Application No: BN/65/22/PL
Site Address: Land at rear of Cedar End Eastergate Lane Eastergate PO20 3SJ
Description of works: Sever land and erection of 1 No bungalow with new vehicular access (resubmission of BN/14/22/PL). This application is a Departure from the Development Plan and is in CIL Zone 3 and is CIL Liable as new dwelling.

Thank you for your internet representation made on 13th June 2022 which has been recorded as an objection with the comments as follows:

Proposed Site Plan
1:200

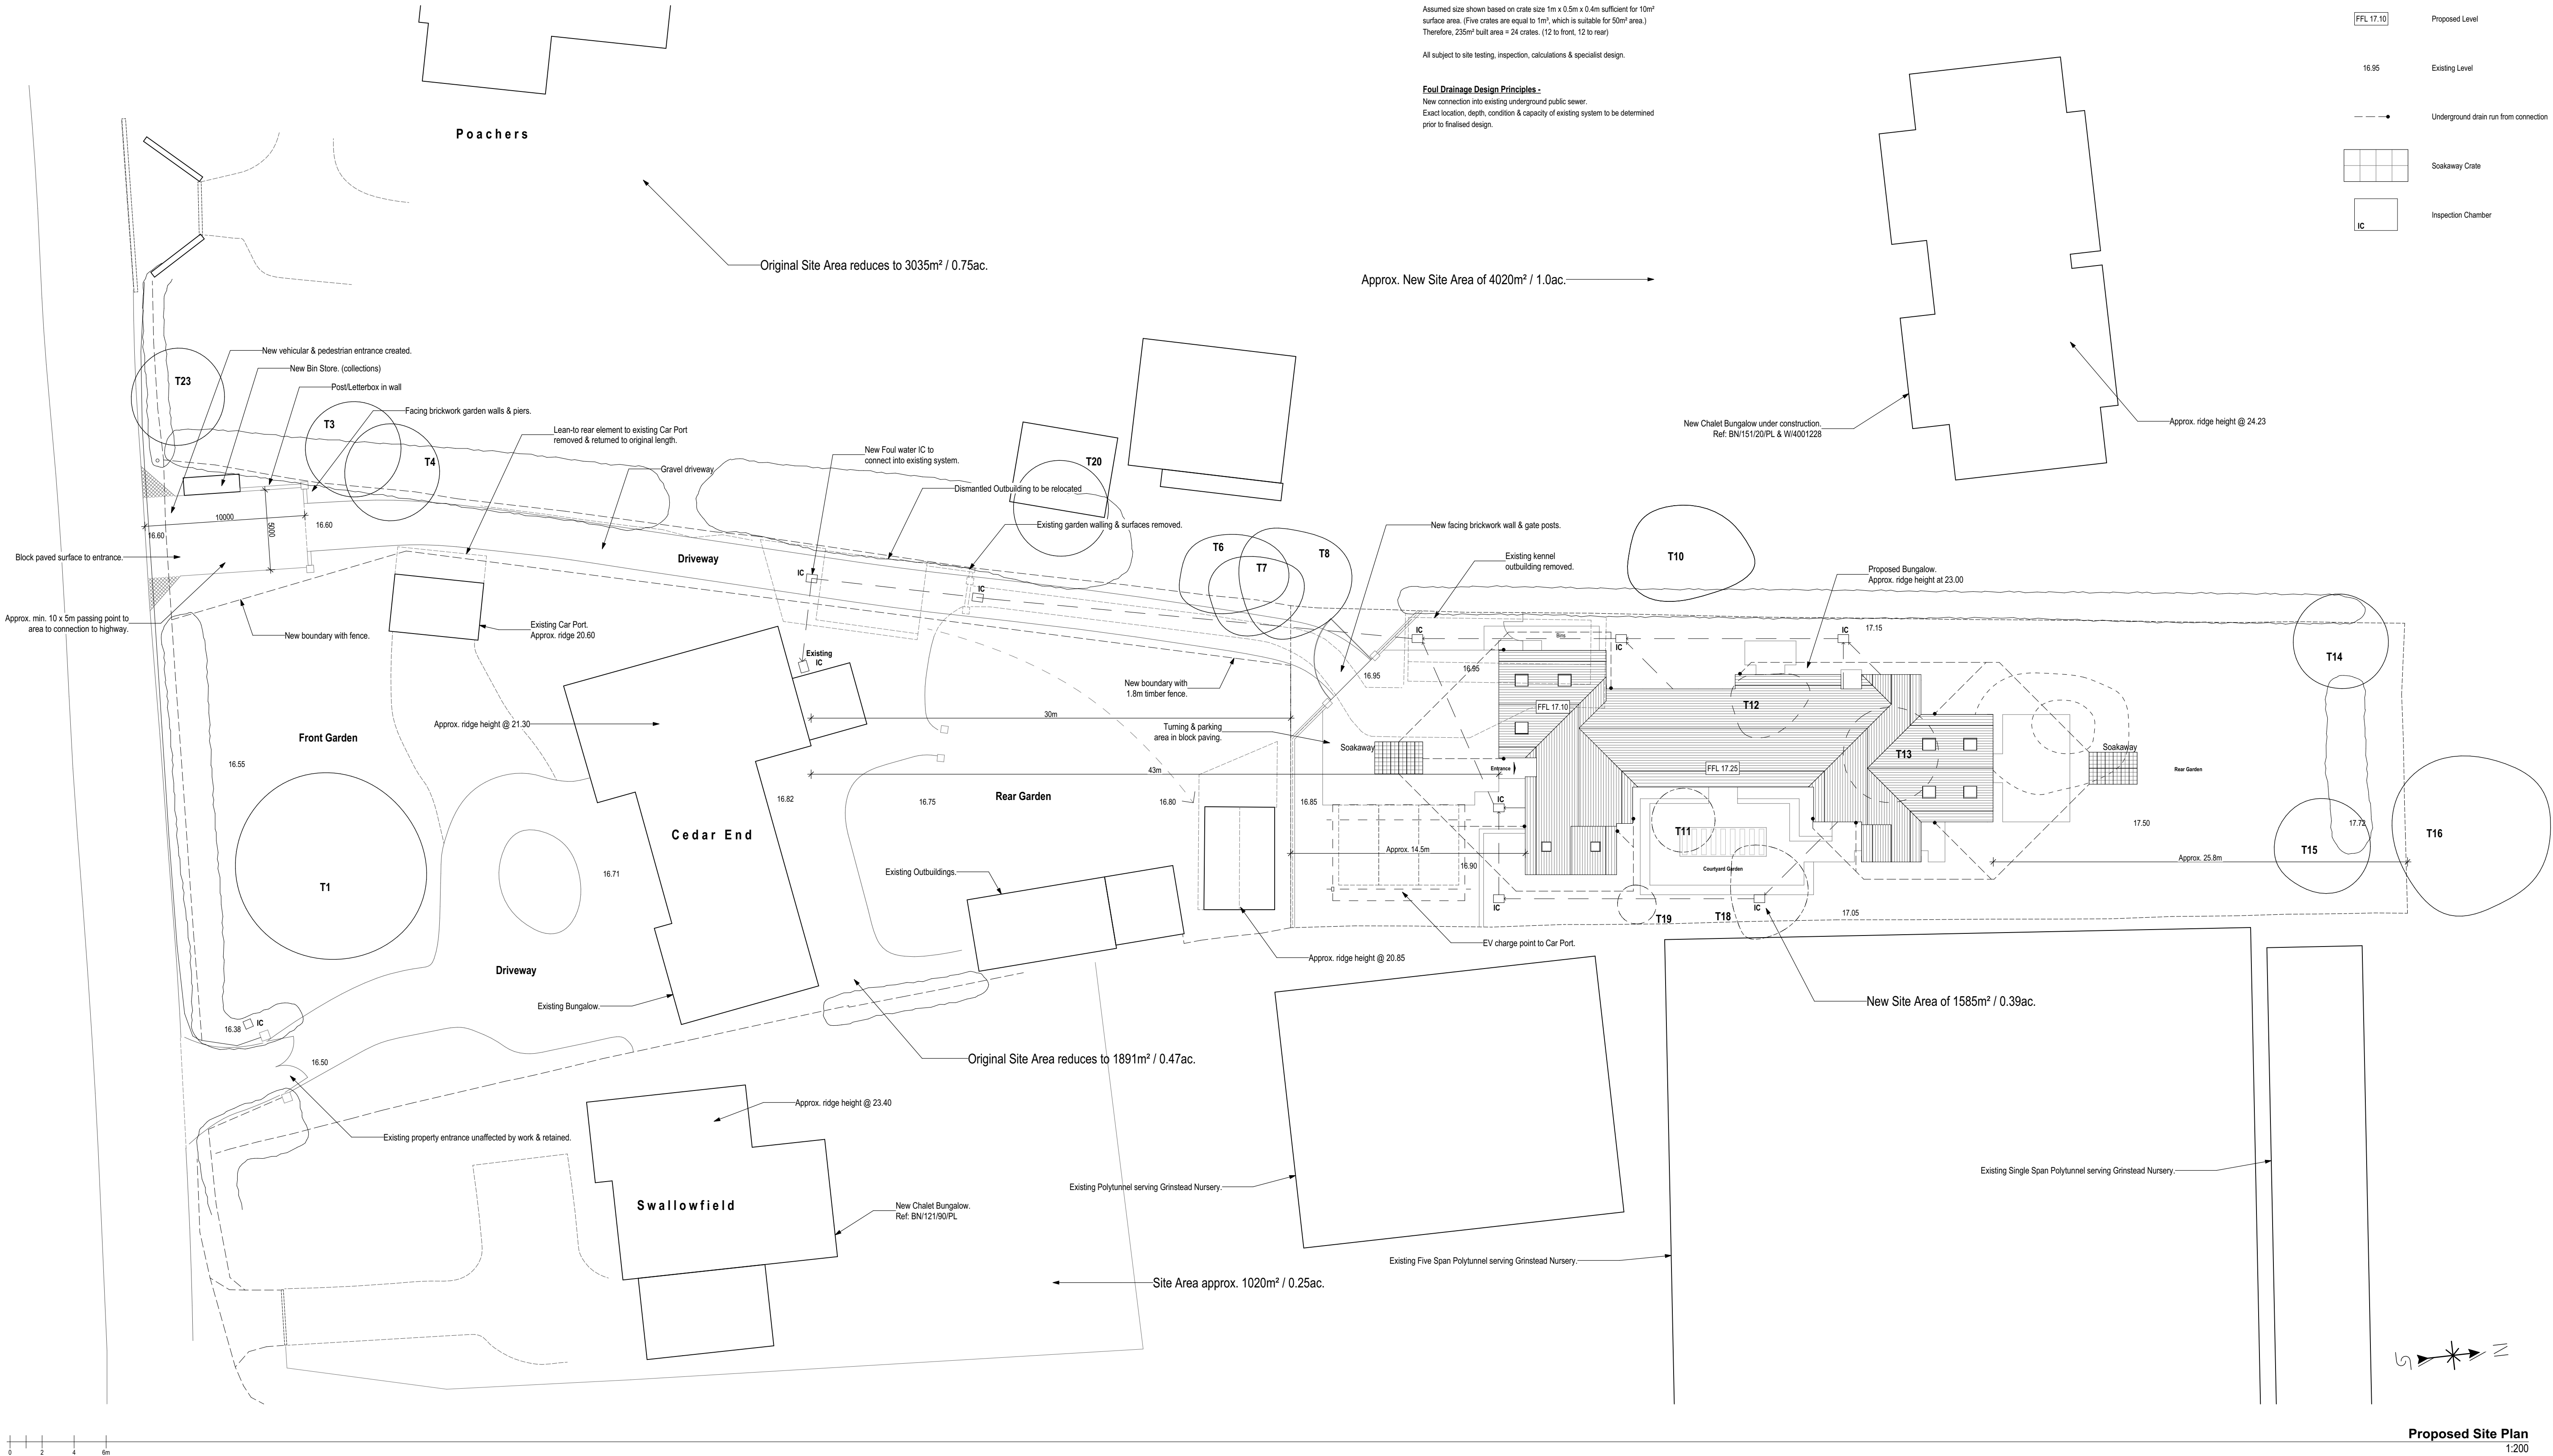
The driveway clearly conflicts with the RPA of the shared Western boundary of the site. There are specimen trees as well as a mature row of leylandii, these are both features and material in providing privacy.

When the access route so clearly encroaches into the RPA of the trees on the boundary, I struggle to see how they can adequately be protected.

There is mention of a modified construction method to address this, I would expect all involved to validate this method as adequate protection and for it to be monitored / policed as being implemented and adhered to at all times - especially during construction when heavy weight and high volume traffic would be expected on this access route.

If ADC cannot confidently address these issues through conditions and monitoring, an alternative means of access should be required.

The Fire Service may have their own comments on the access, based on our own experiences - width of access, ability to turn around on-site, access to adequate water supplies.
